From: Paul Cann
Sent: 19 July 2017 15:54
To: Planning.Responses
Subject: RE: Planning Consultation on: Y/44/17/OUT

Engineers comments in respect to surface water drainage:

APPLICATION Y/44/17/OUT

Site Address: Land at Stakers Farm North End Road Yapton

TITLE	Proposed Site Layout	
SCALE	1:1000 @ A3	DWG NO. 3

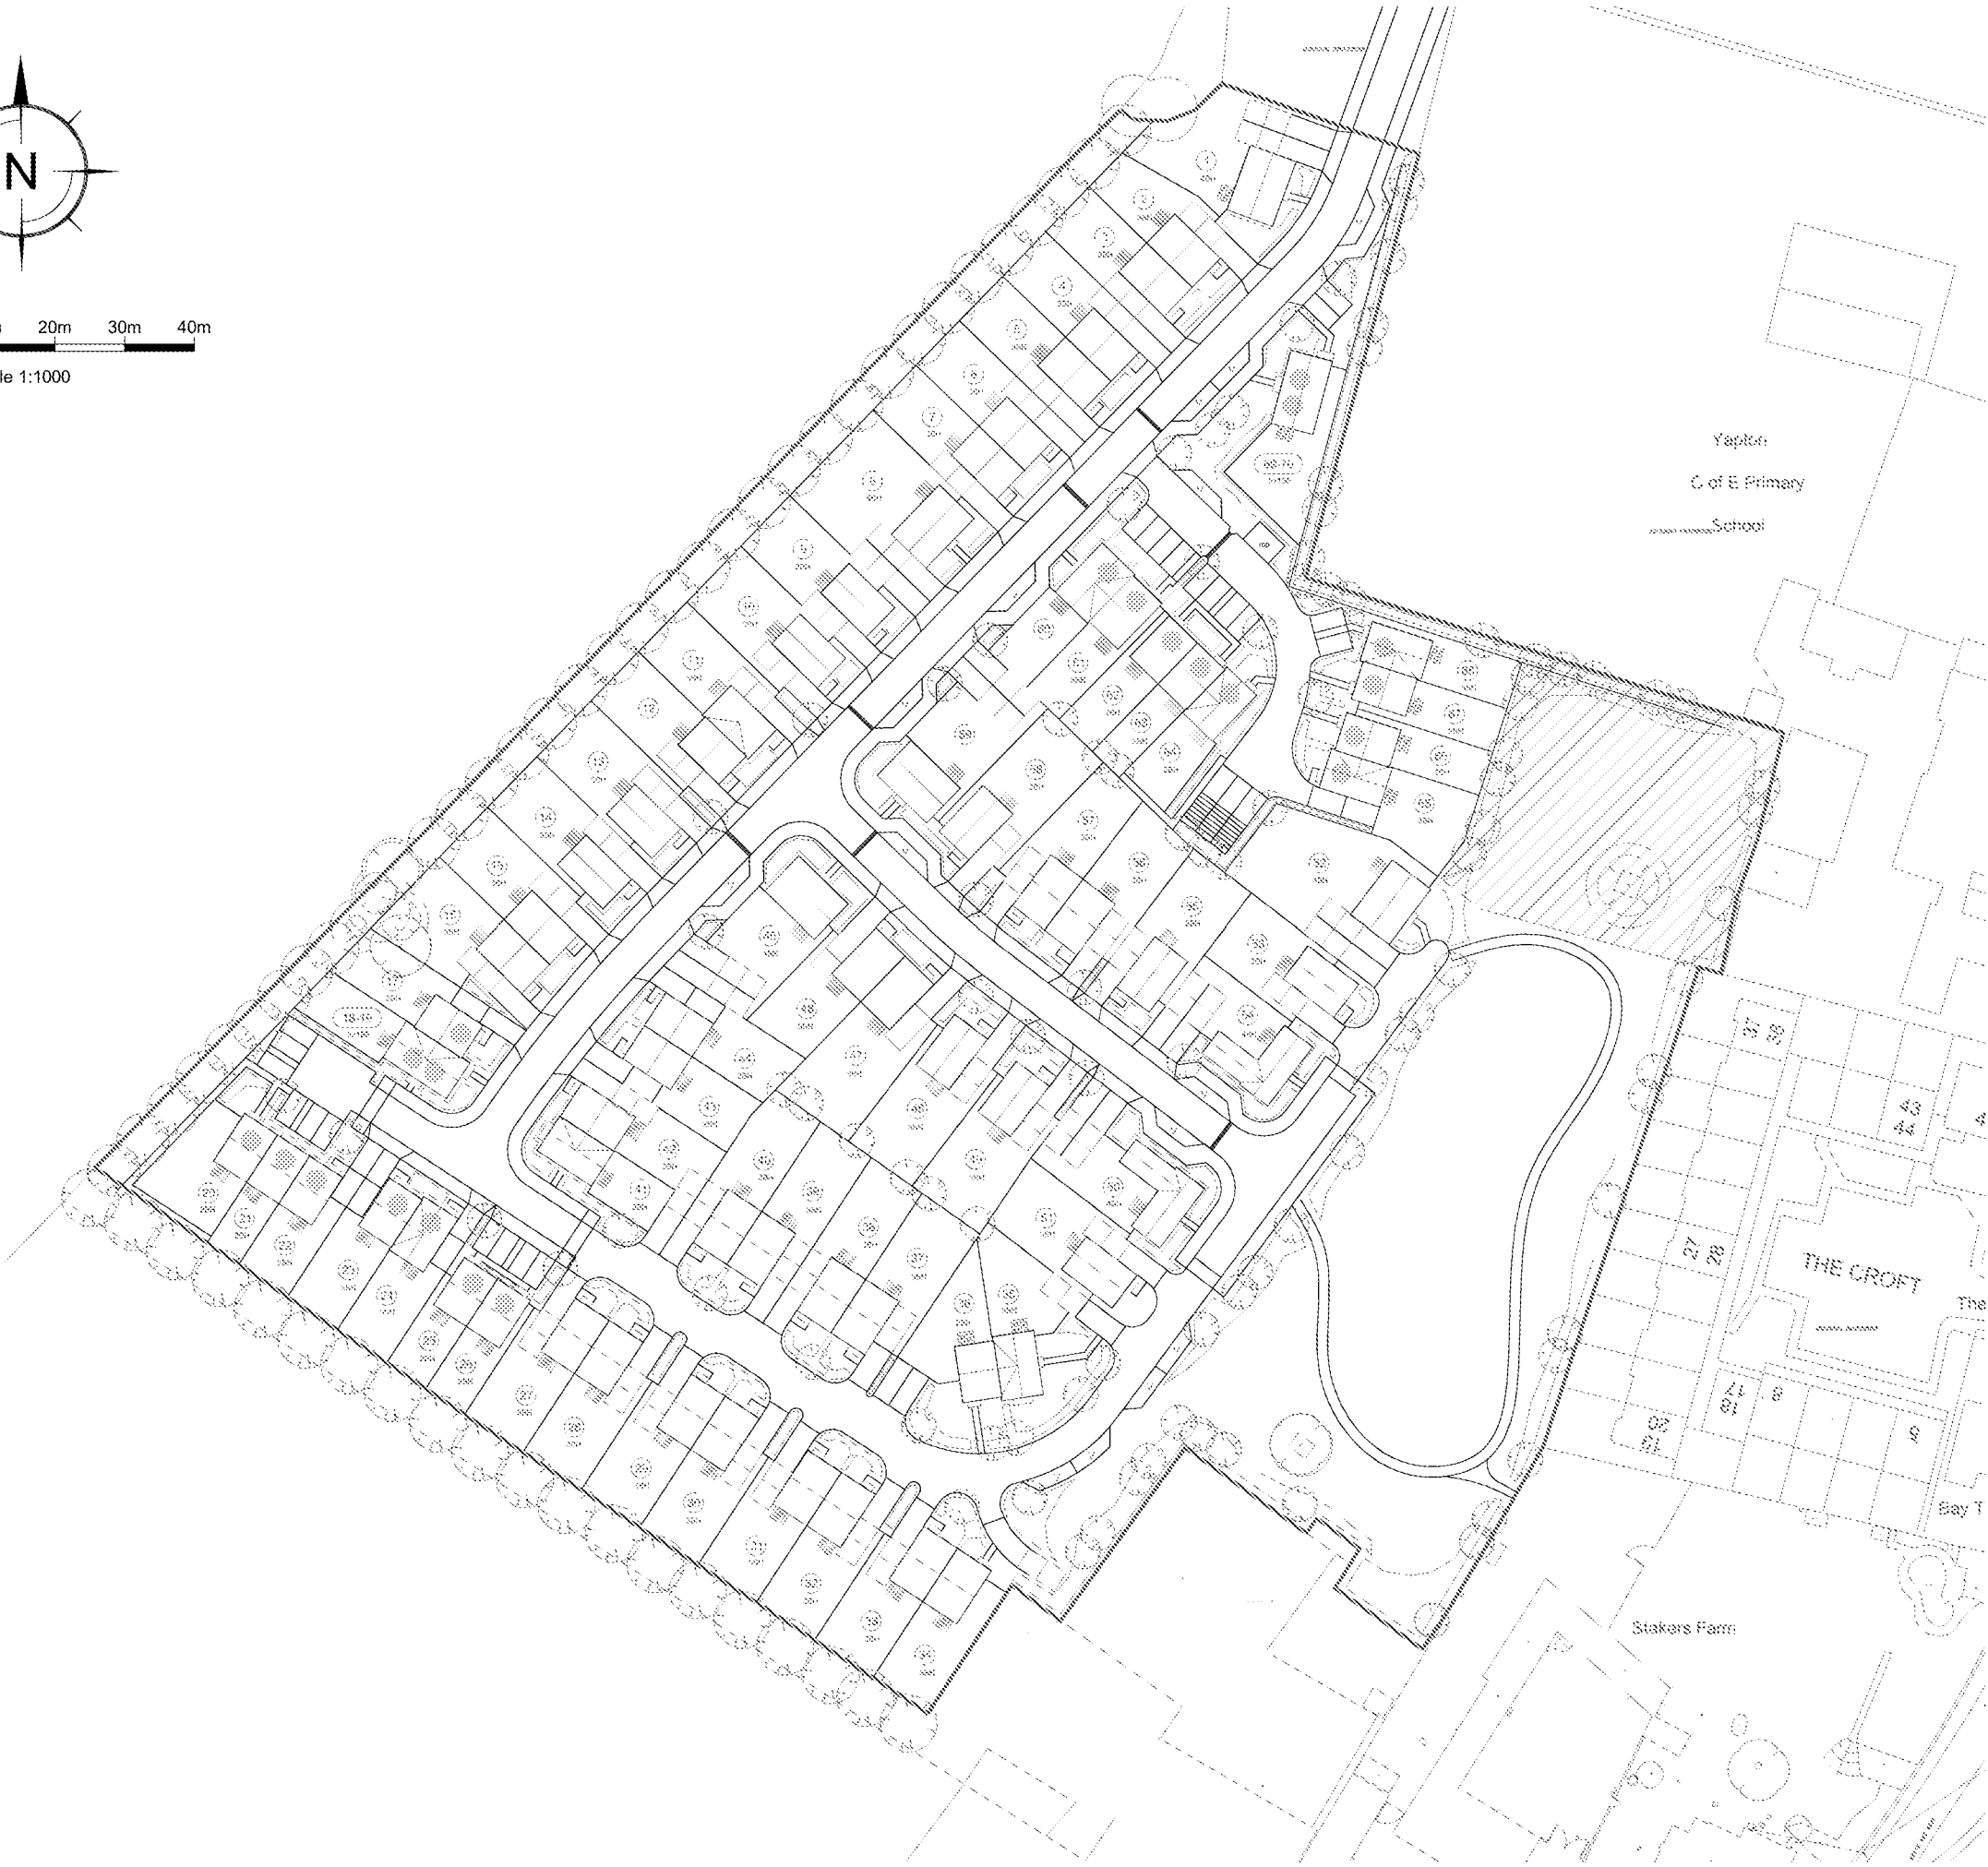
The FRA stipulates that the fall of the land is to the north and west. Therefore the lowest areas of the site will be on those boundaries. If the perched water table exists, then the design of the drainage scheme could prove challenging and will need sufficient open space areas to locate shallow infiltration ponds etc. Unfortunately, the main open space area on the proposed development layout is shown on the eastern boundary (potentially the highest point of the site). The development layout may therefore need significant alteration, depending on the outcome of further ground investigations.
